Re: WA/68/26/PL — Land North of The Greenway, West Walberton Lane, Walberton, BN18 0QS

Further comments — ownership certificate and access width

Location Plan

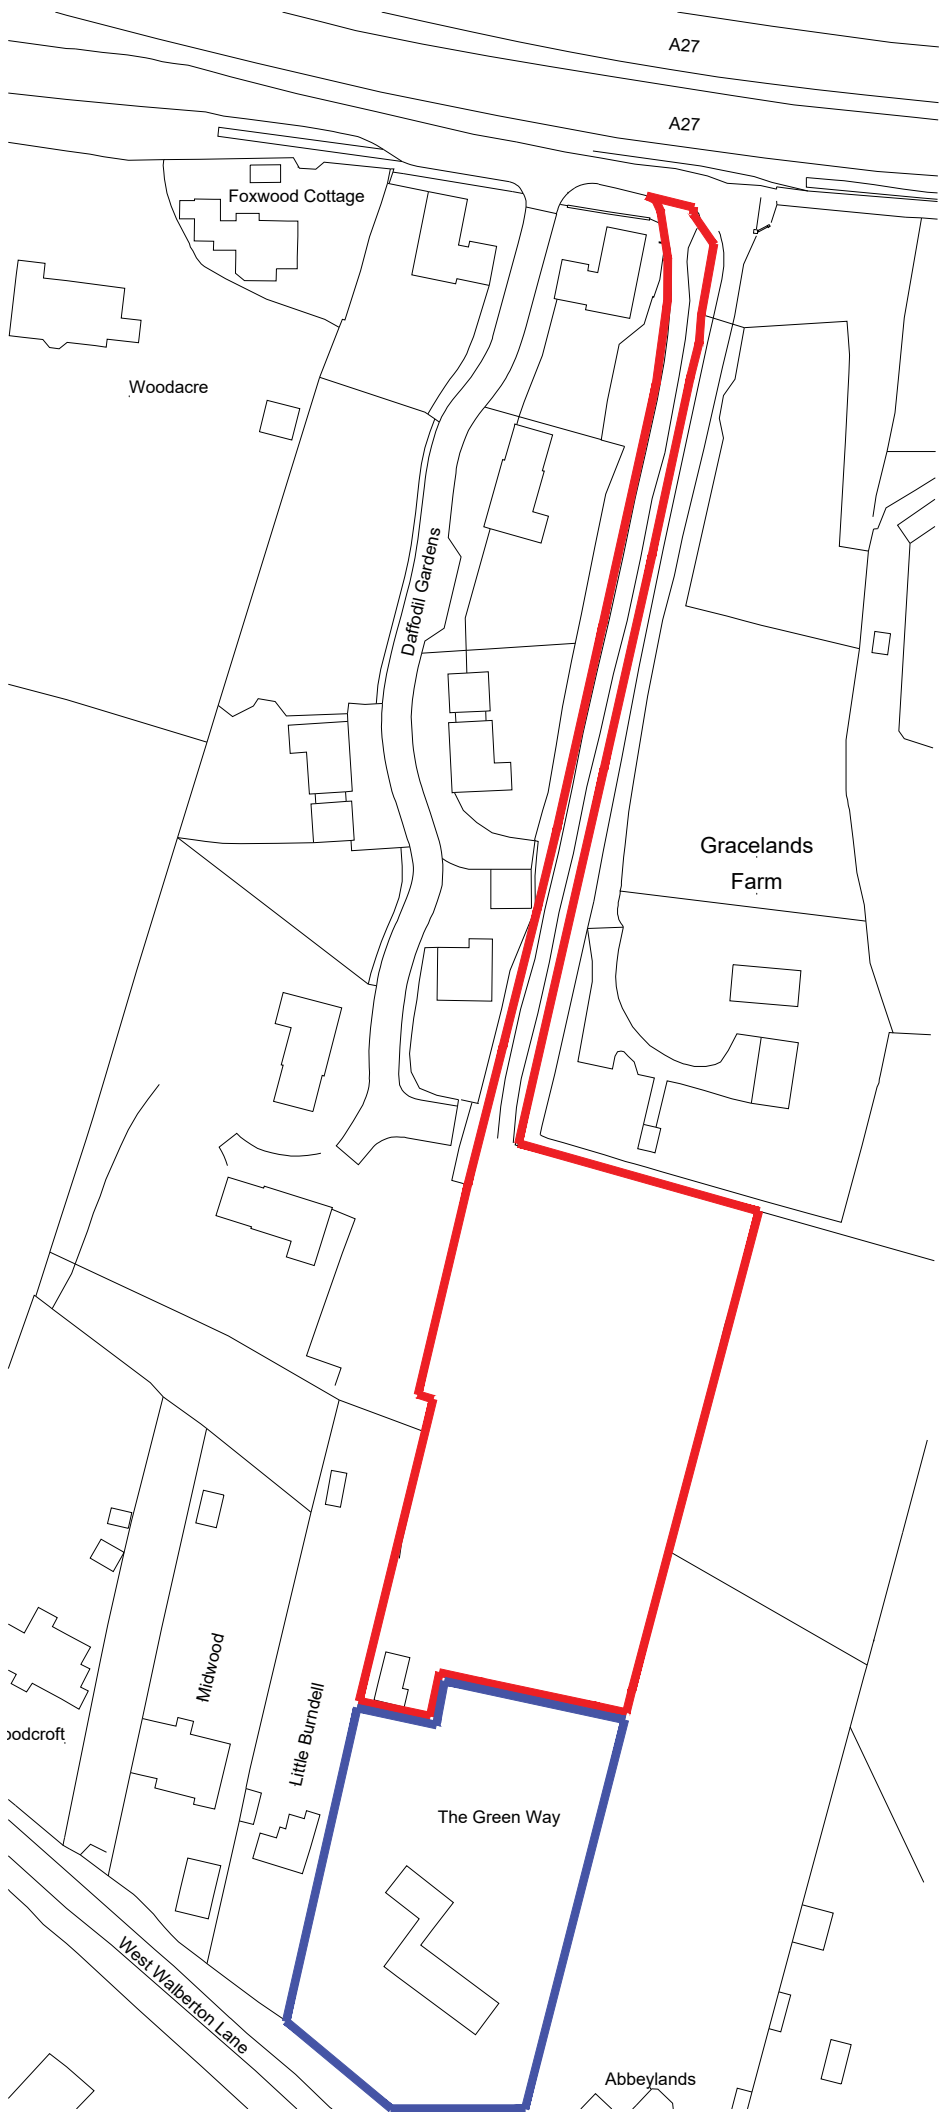
The figure below shows the same corner on three drawings: the 2008 Deed plan, where the Yellow Land is shown flaring out at the junction with Arundel Road at point B; the registered title plan for WSX416417, which shows the same corner at point K; and the Location Plan submitted with the application.

On that basis it appears that part of the access land is owned by Elivia Homes (Southern) Limited, and that the outer 0.3 metres remains registered under title WSX285497 to Kenneth Mark Poland,

I would ask the Council to confirm which ownership certificate has been given and, if Certificate A, to satisfy itself that it is correct and that any notice required under Article 14 has been served.

Fire Tender Access and Egress

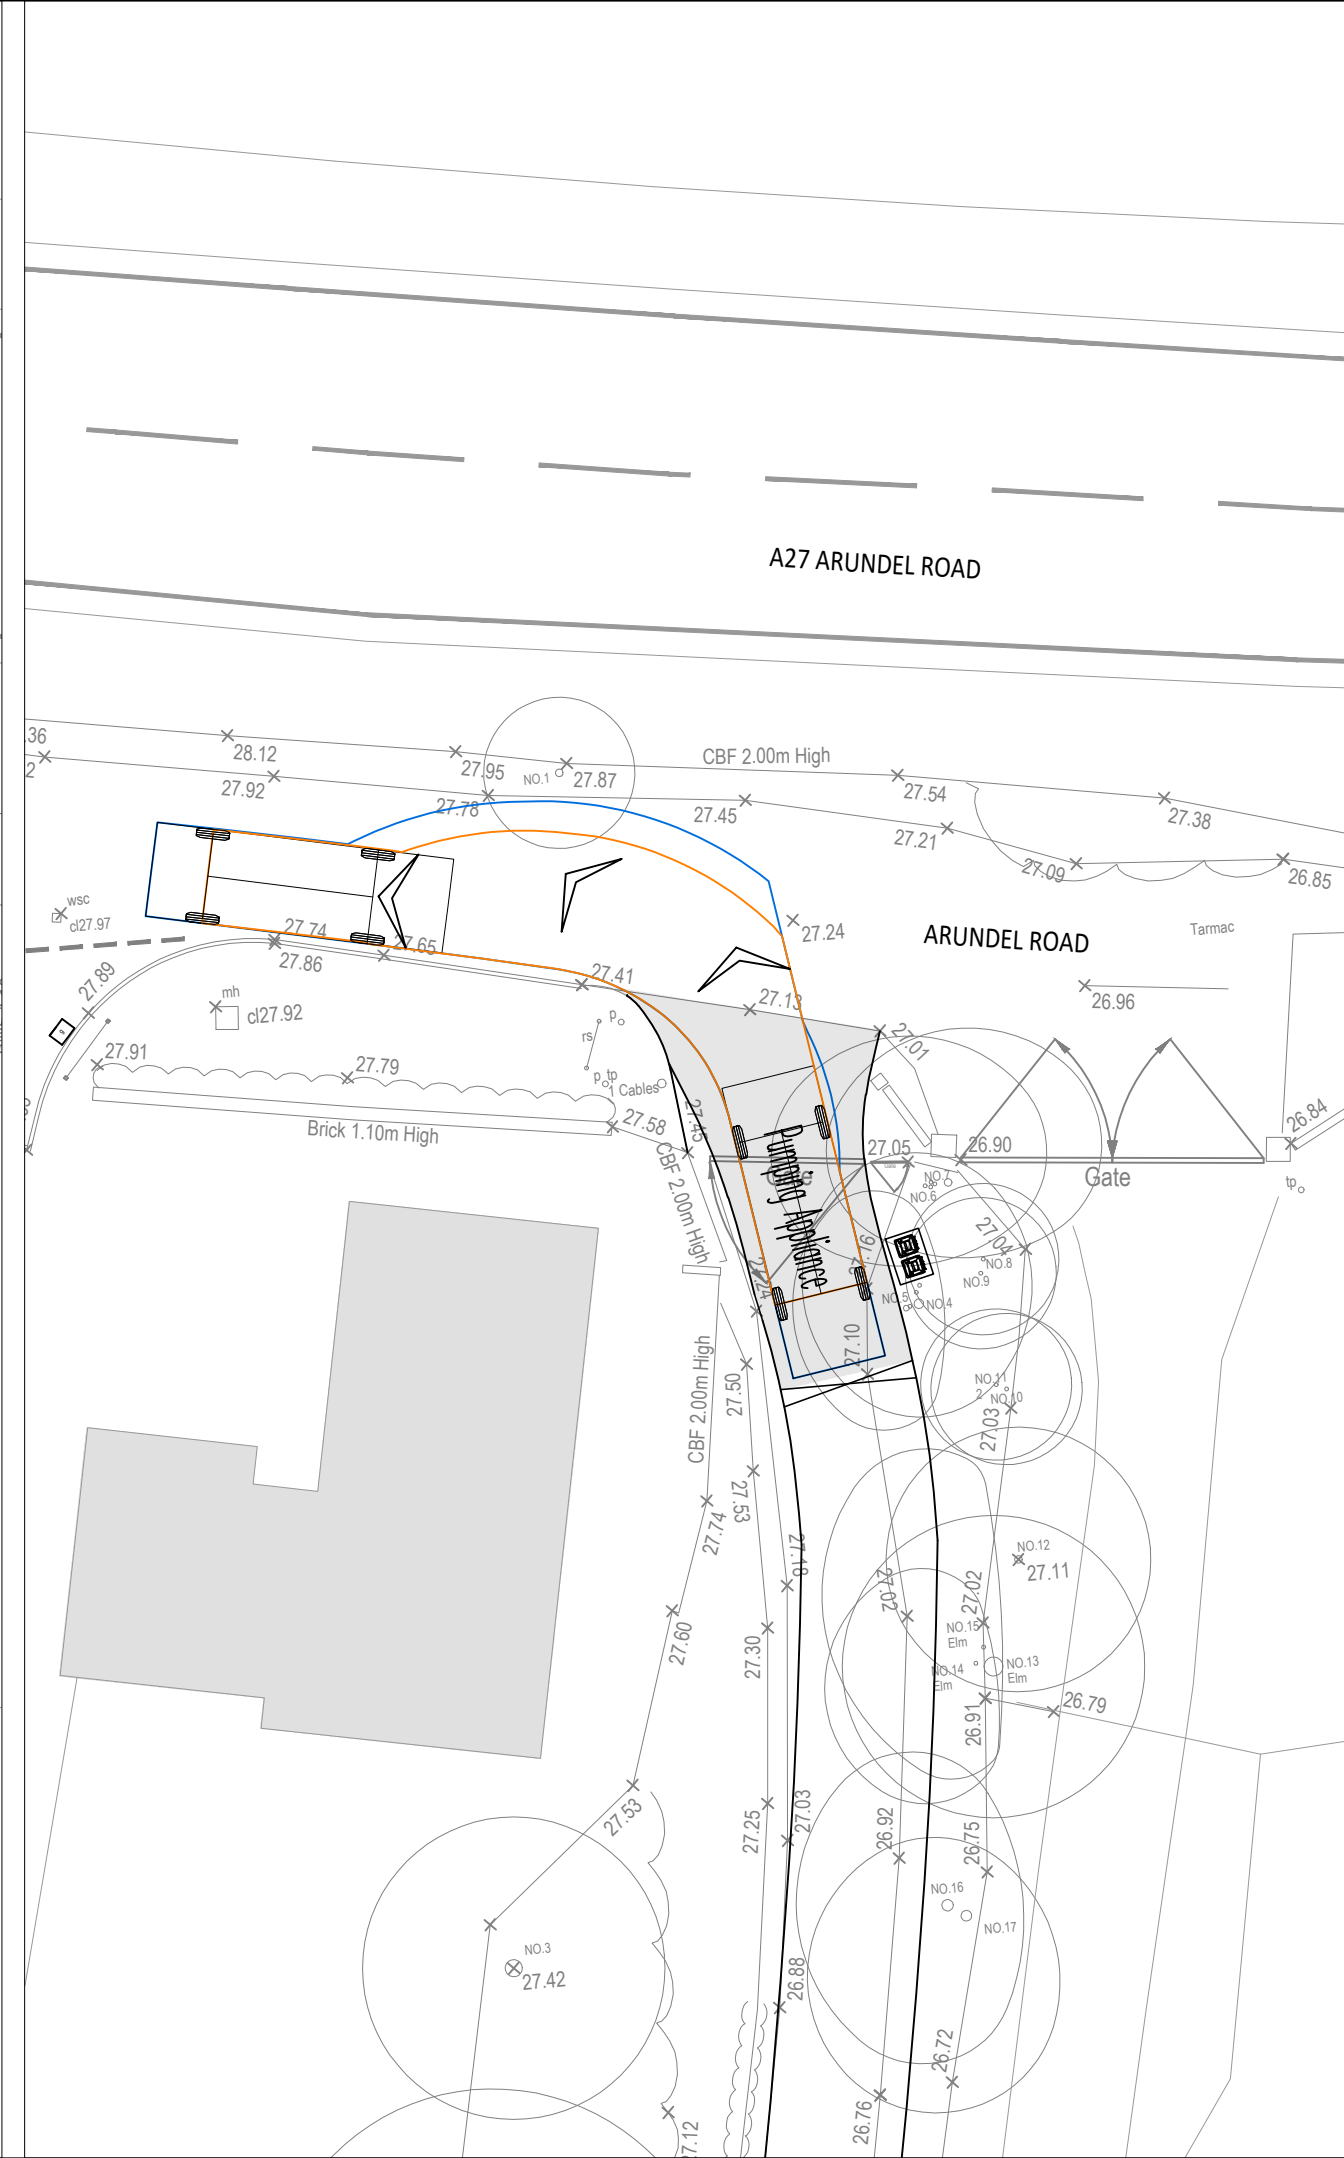
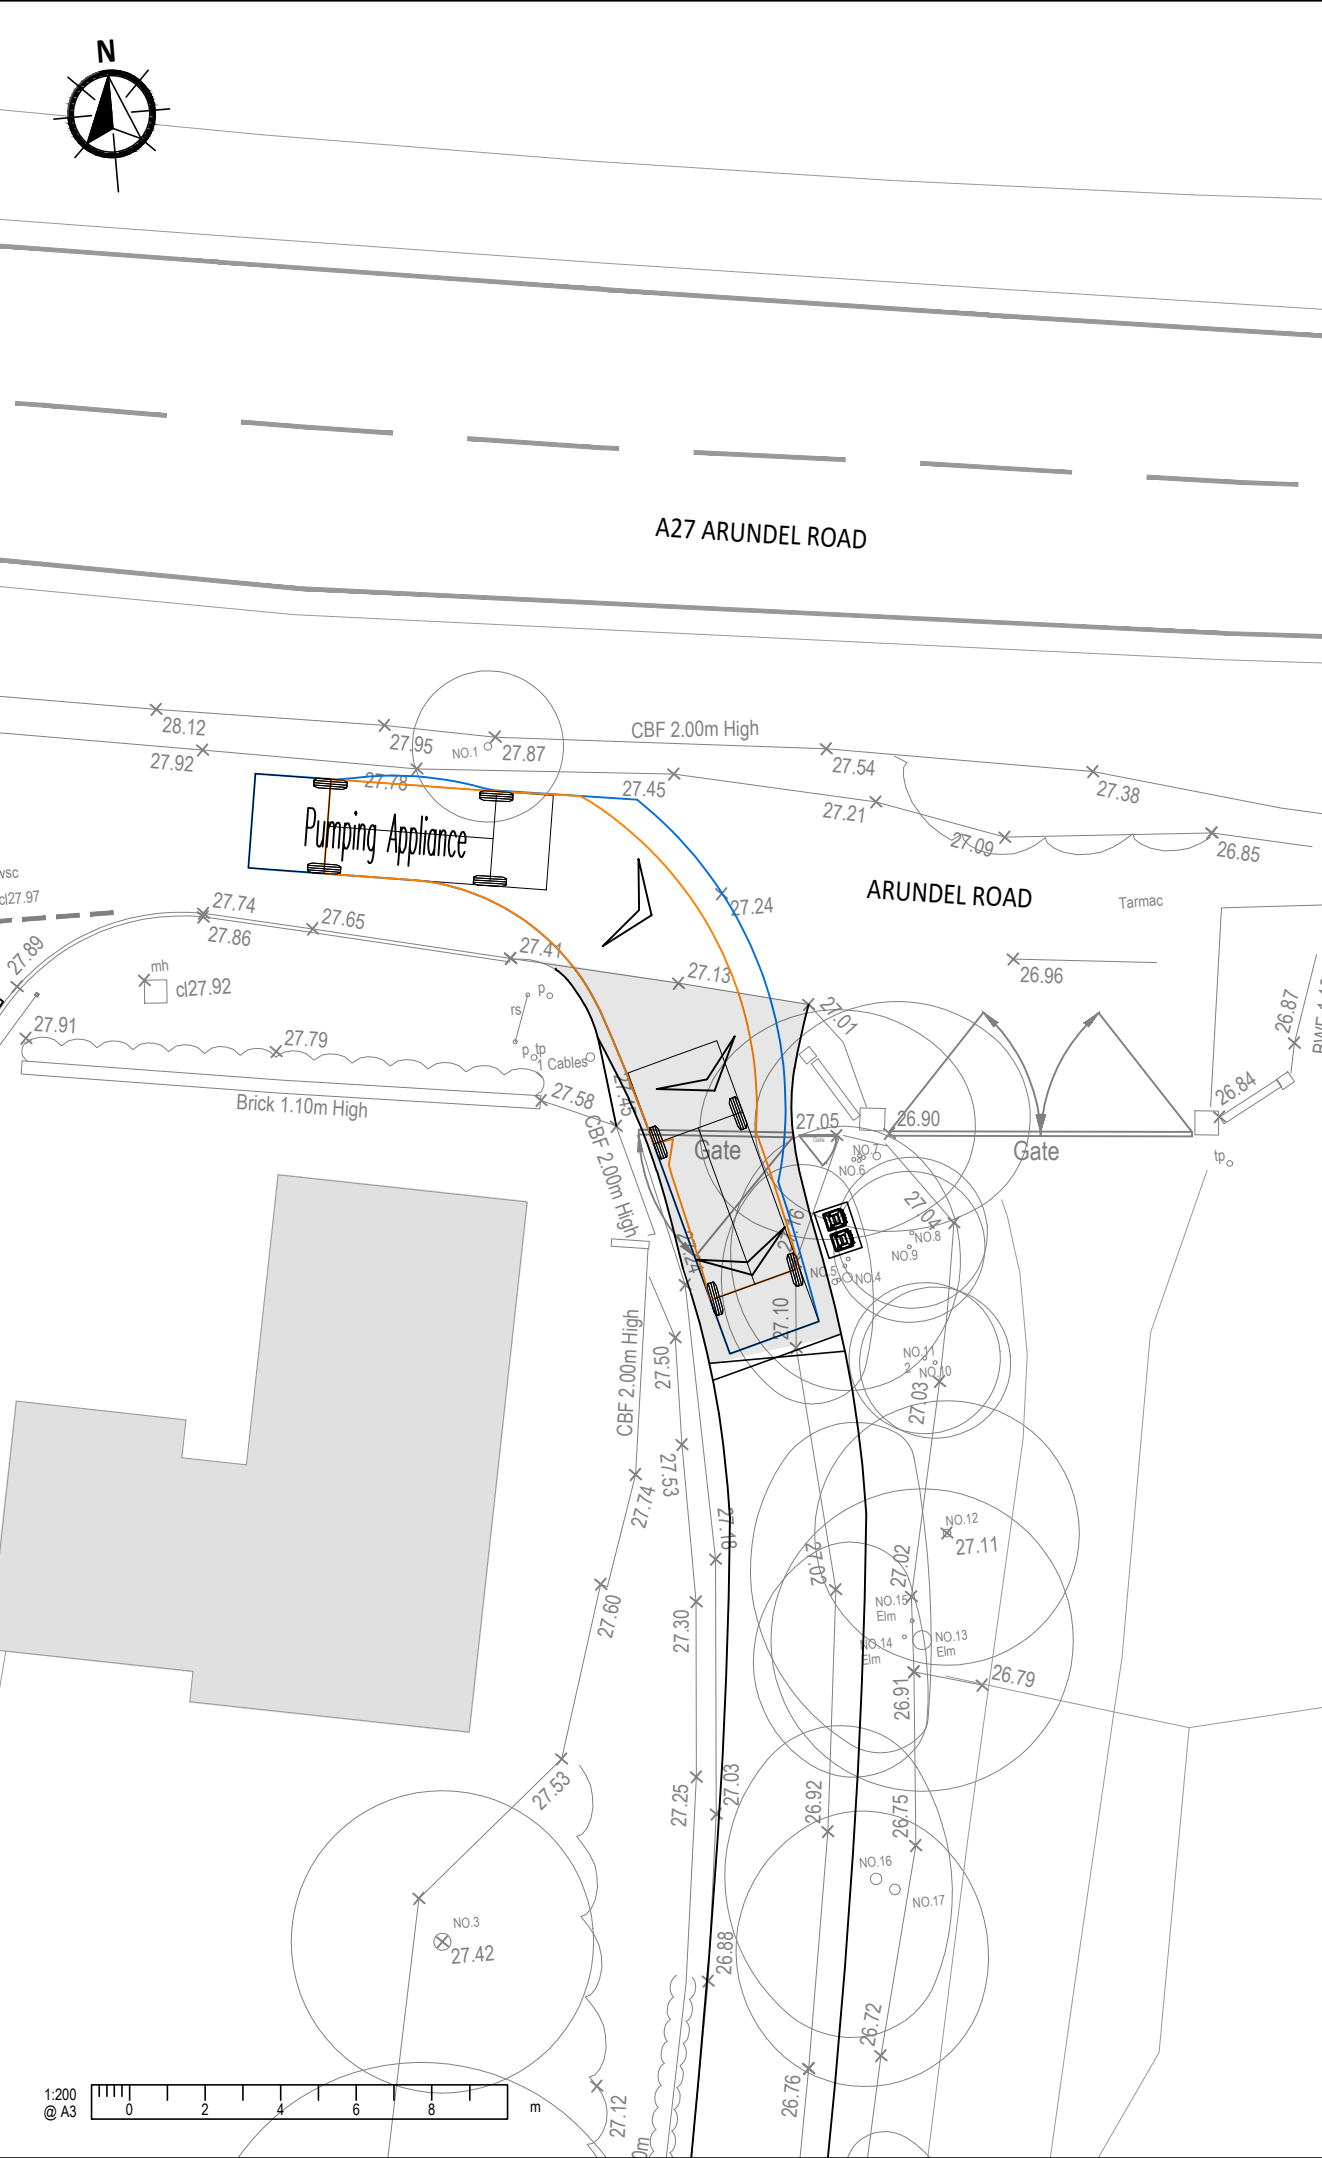
The swept-path drawings state the dimensions of the vehicles to be accommodated — a 2.5 metre track width for the fire tender — but not the width of carriageway to be provided.

Without a stated width I do not see how the Council or the highway authority can assess whether the access as proposed is adequate along its length, or determine over whose land the widening would fall. I would ask that the applicant be required to state it.
